# CITY OF ALBUQUERQUE

**Re: New Paving at 4610-A McLeod NE - Grading and Drainage Plan  
Engineer's Stamp dated 4-17-05 (F17 - D91)**

GRADING & DRAINAGE PLAN

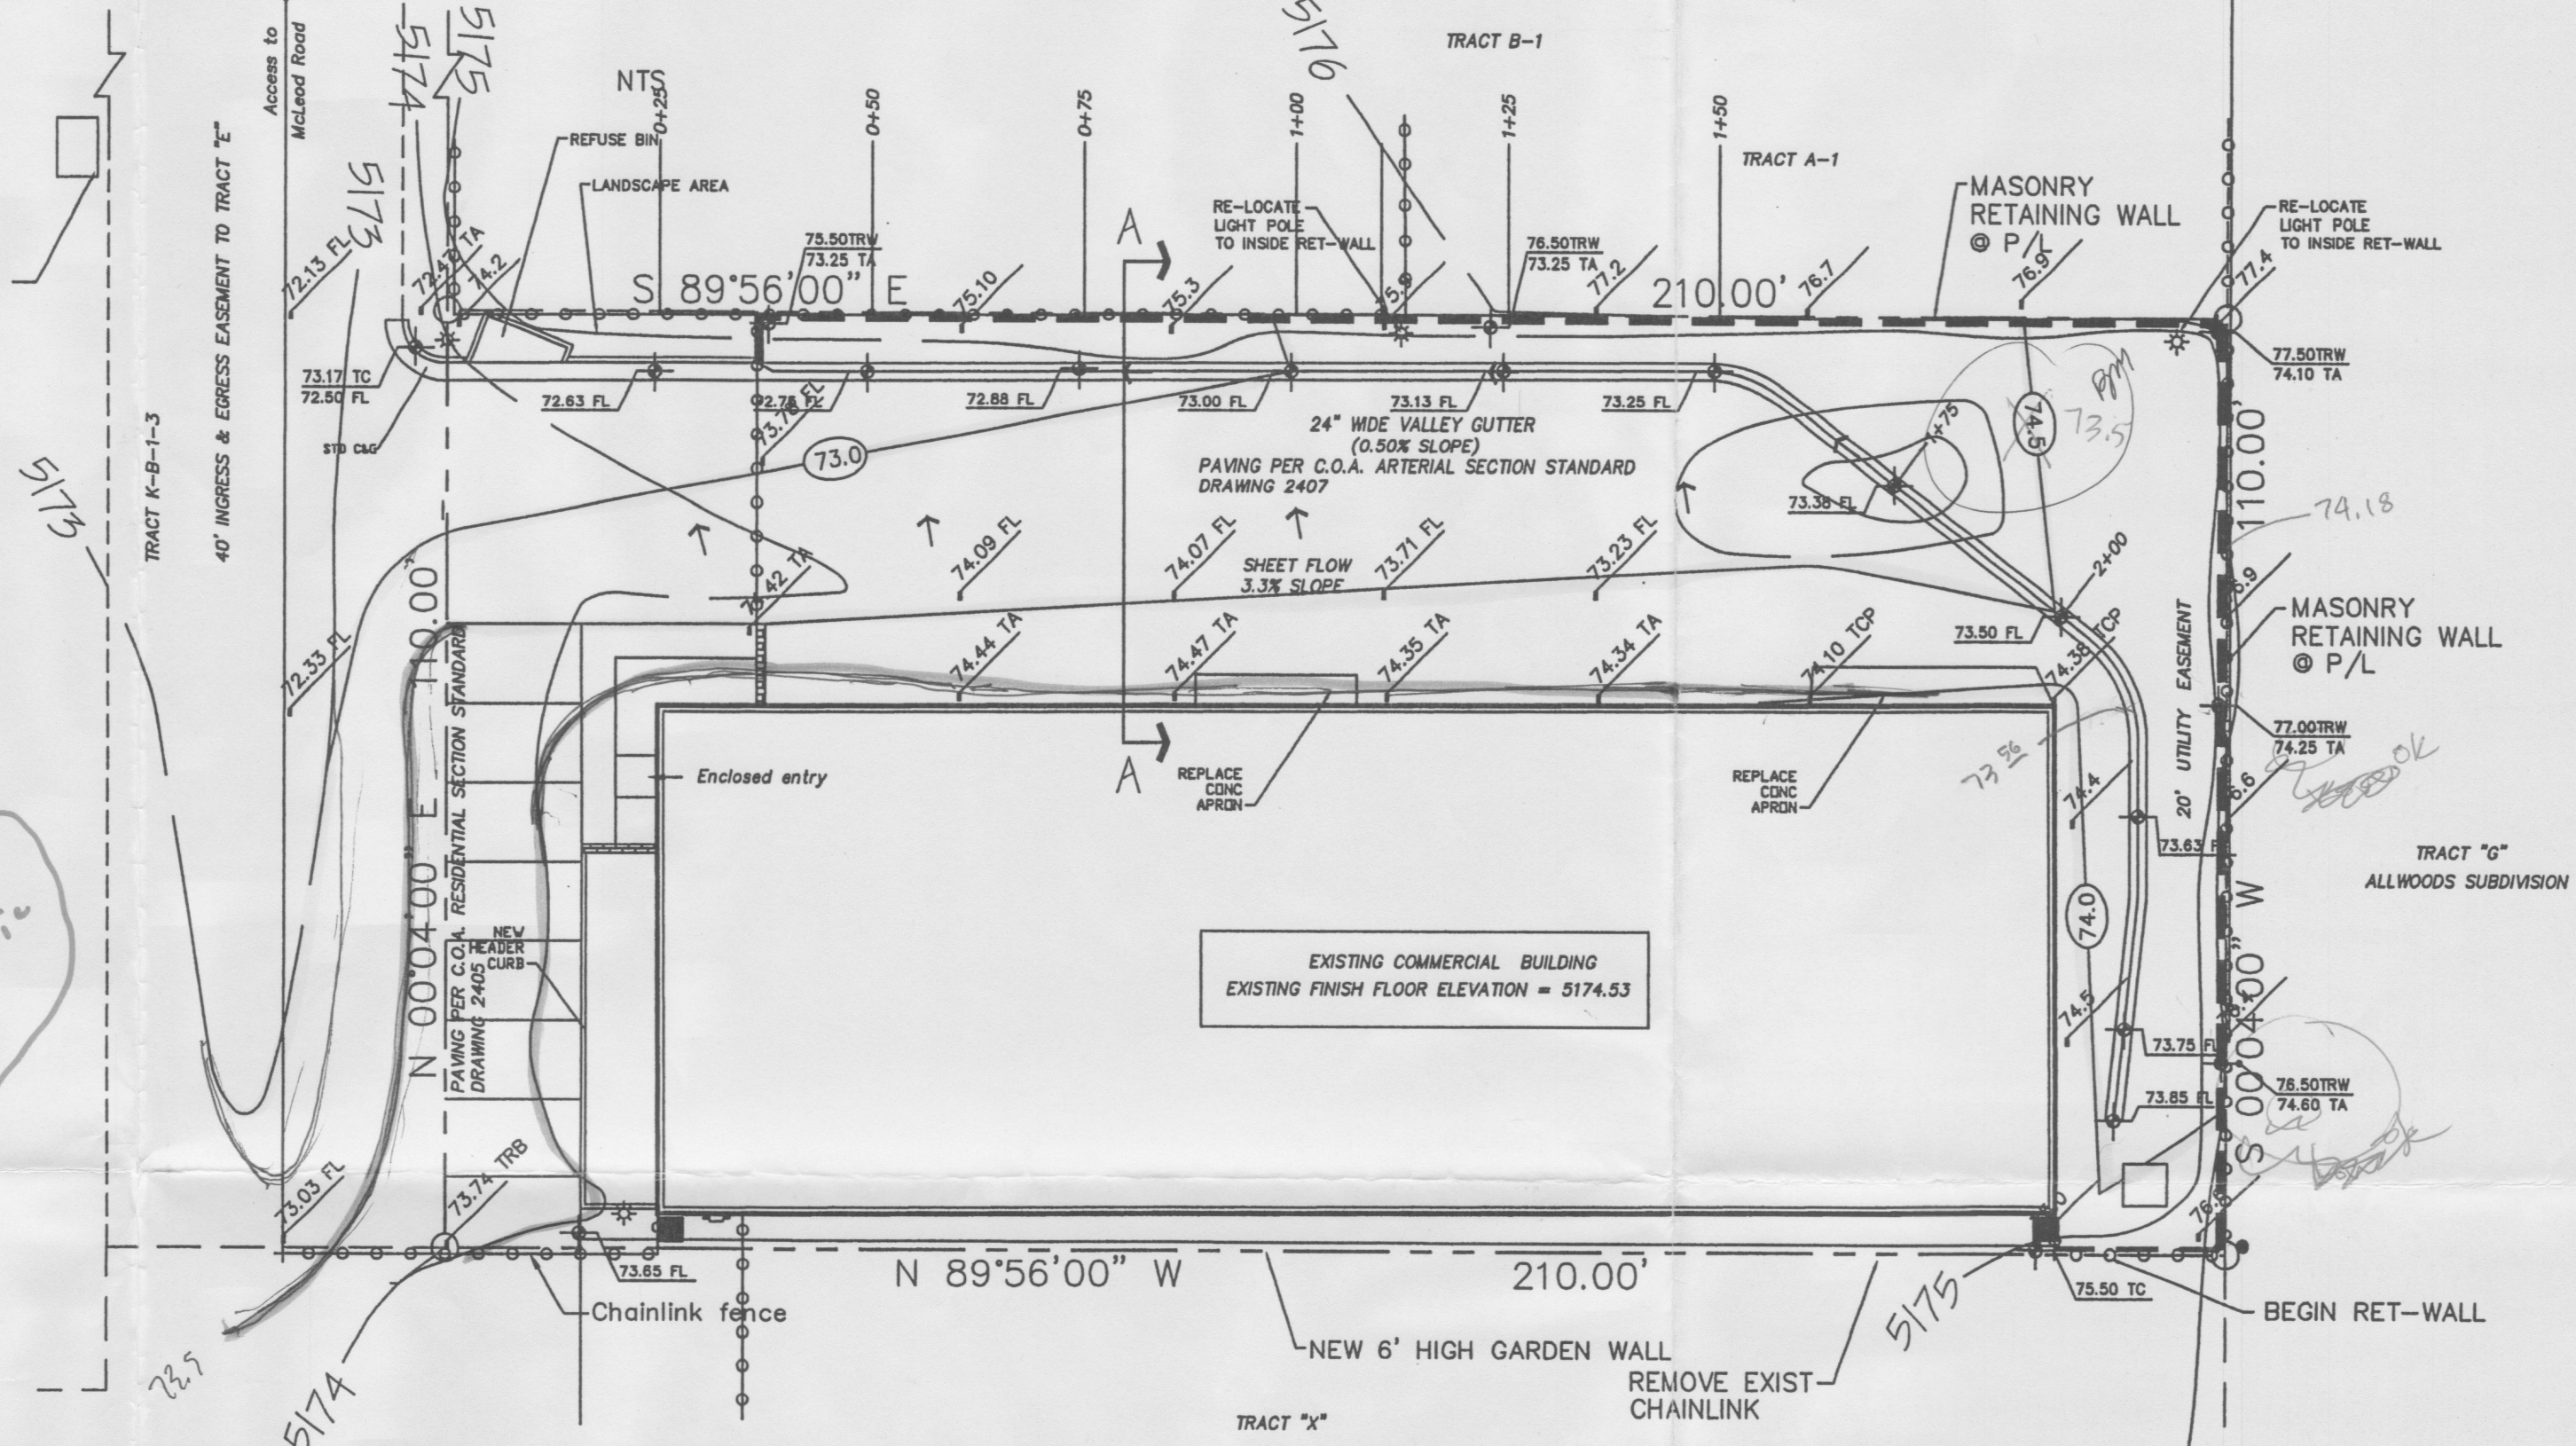
Based upon the information provided in your submittal dated 4-18-05, the above referenced plan is approved for Grading and Paving Permit provided the 74.5 contour label is corrected to read 73.5.
